EPC STORMWATER REVIEW COMMENTS
IN ORANGE BOXES WITH BLACK TEXT

GRADING AND EROSION CONTROL PLAN

JUDGE ORR ROAD RV PARK AND STORAGE

PCD PROJECT NO. PPR-16-040

JUDGE ORR ROAD RV PARK & STORAGE
COLORADO SPRINGS, COLORADO
DRAINAGE, GRADING & EROSION CONTROL COVER

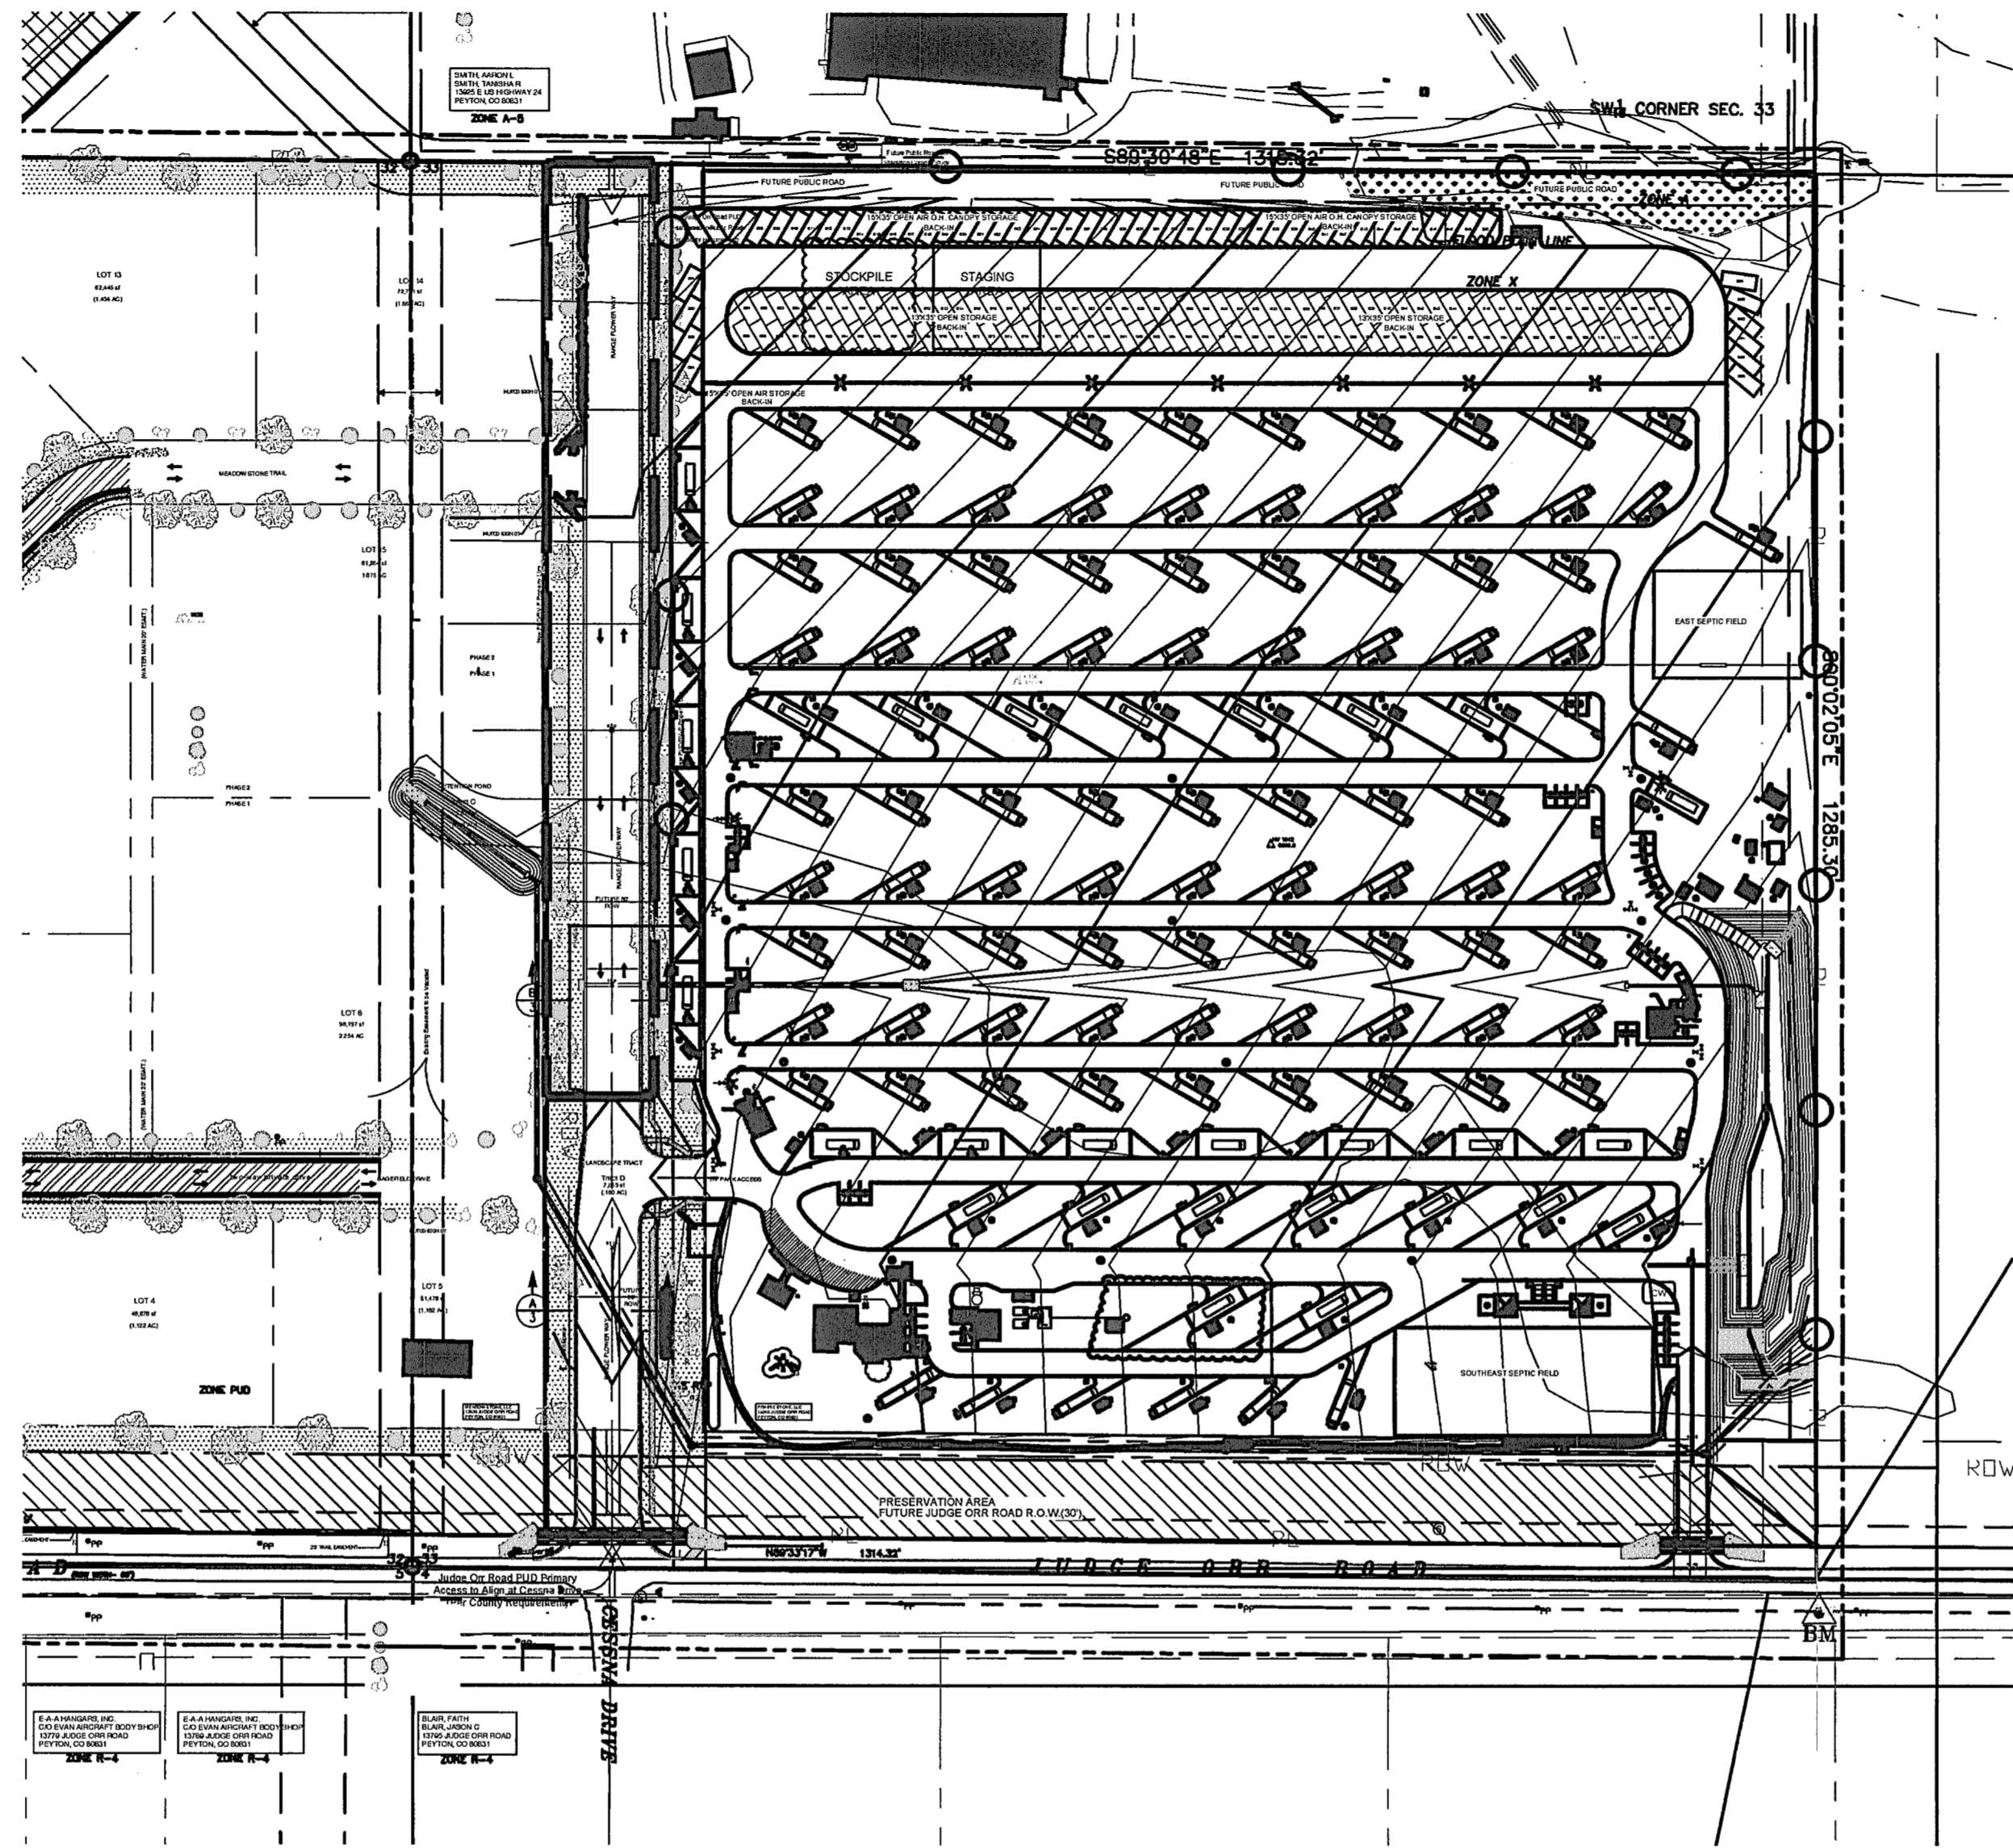
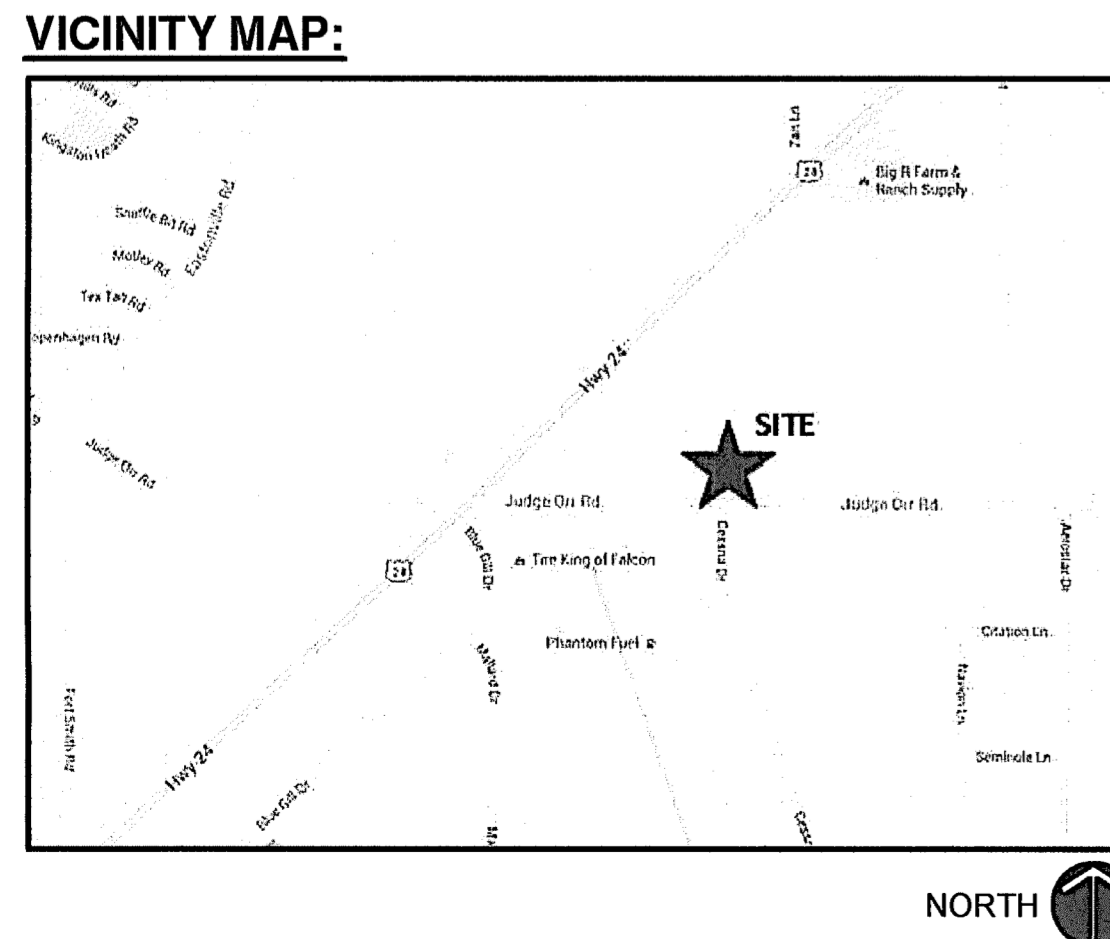
Revise to match Checklist Item "ff"

Per this paragraph of the EPC signature block, the GEC Plan will need to be brought up to current criteria. Use the latest GEC Checklist that I uploaded to EDARP to see what needs to be added to plans.

Add CDR222 (typ comment all sheets)

JUDGE ORR ROAD RV PARK & STORAGE
 COLORADO SPRINGS, COLORADO
 DRAINAGE, GRADING & EROSION CONTROL PLAN

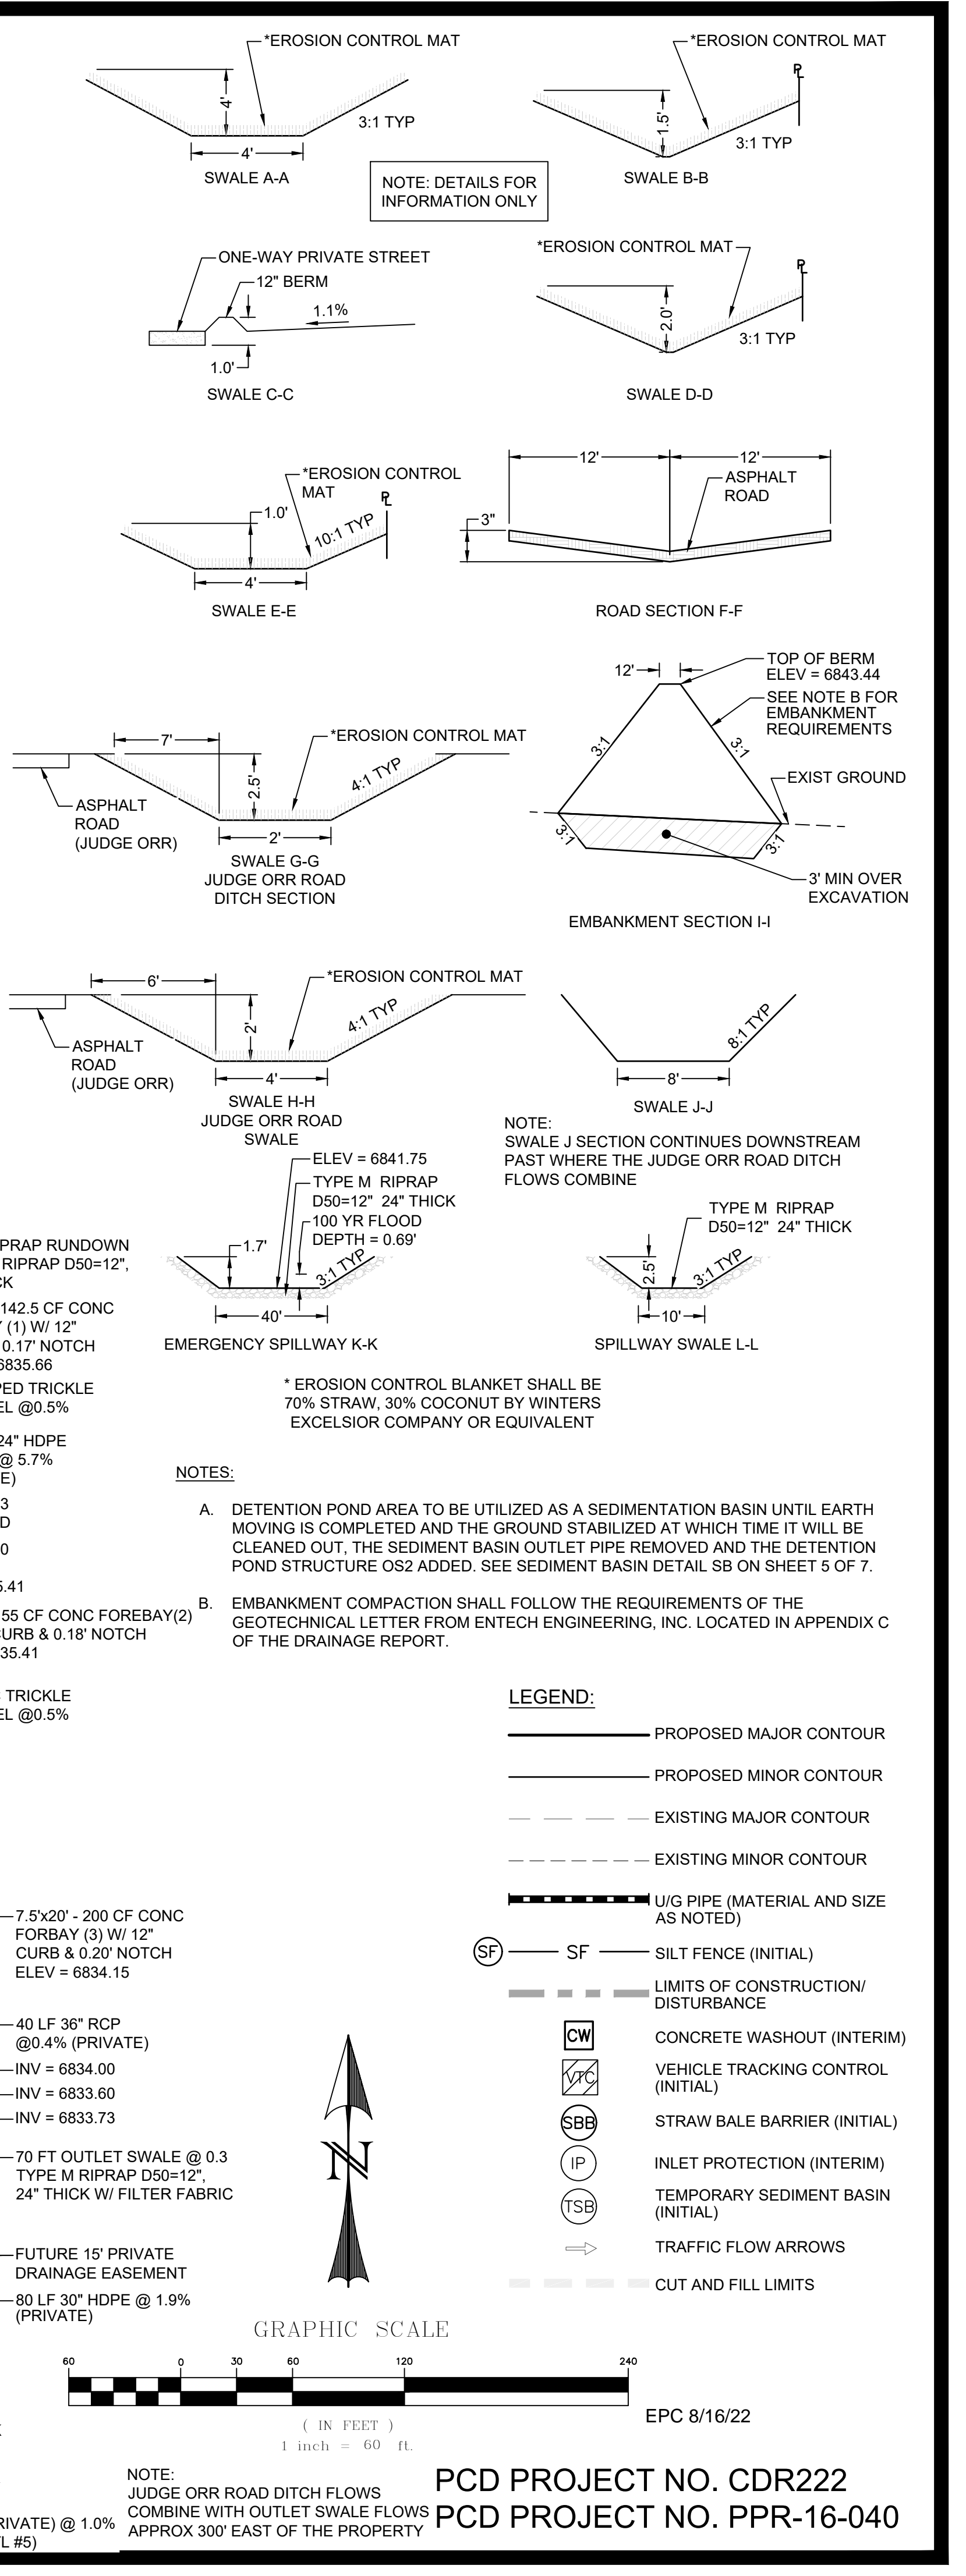
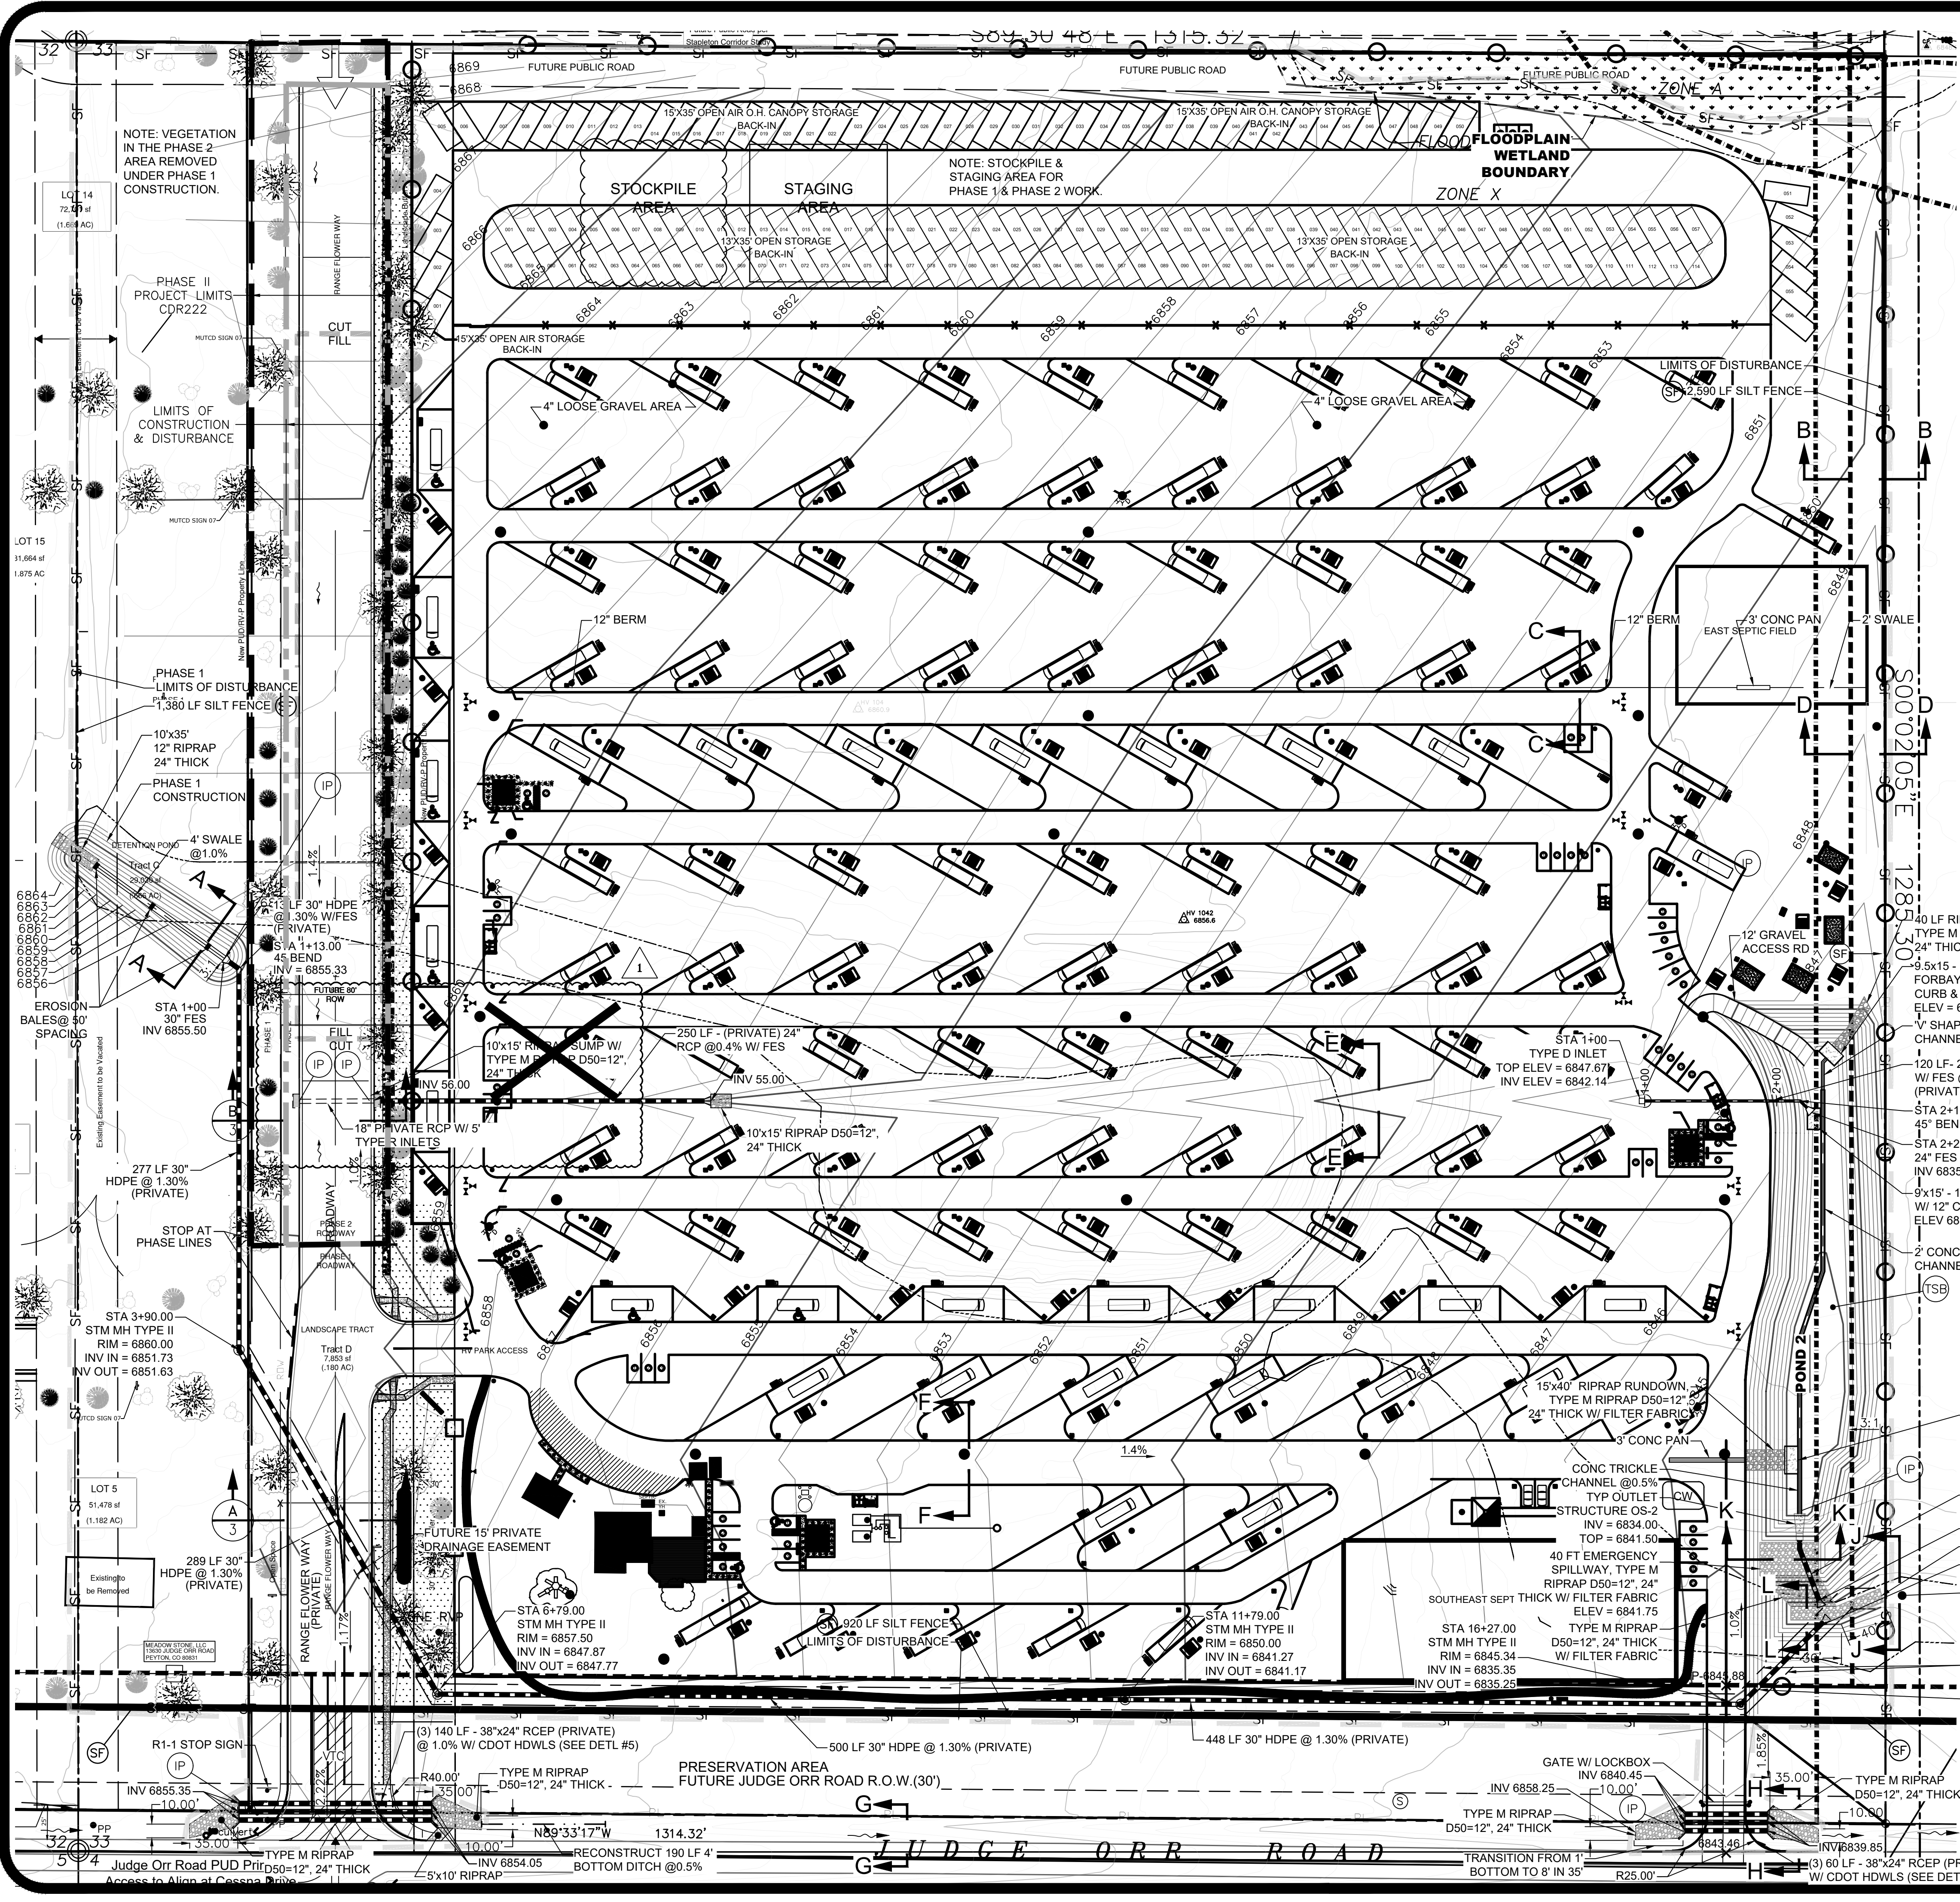
Only show area of proposed improvements as black and/or within a bubble/cloud. All other work should be "grayed-out" to show that is existing and/or not part of this submittal.

Same with BMPs and their callout bubbles, gray-out all those not associated with CDR222

Please use the latest base drawing used in the CD's that does not show this traffic circle, since the traffic circle is part of an old design.

Checklist Item "p" - delineate areas of cutfill or if possible notate a description of general locations of cutfill

Checklist Items H and M. If "limits of disturbance" and "construction boundary" are the same, change to "limits of construction/disturbance" or otherwise show as separate line types for each on the legend and figure.

Checklist item "v" add a note next to each BMP that labels their phase (initial, interim, final)
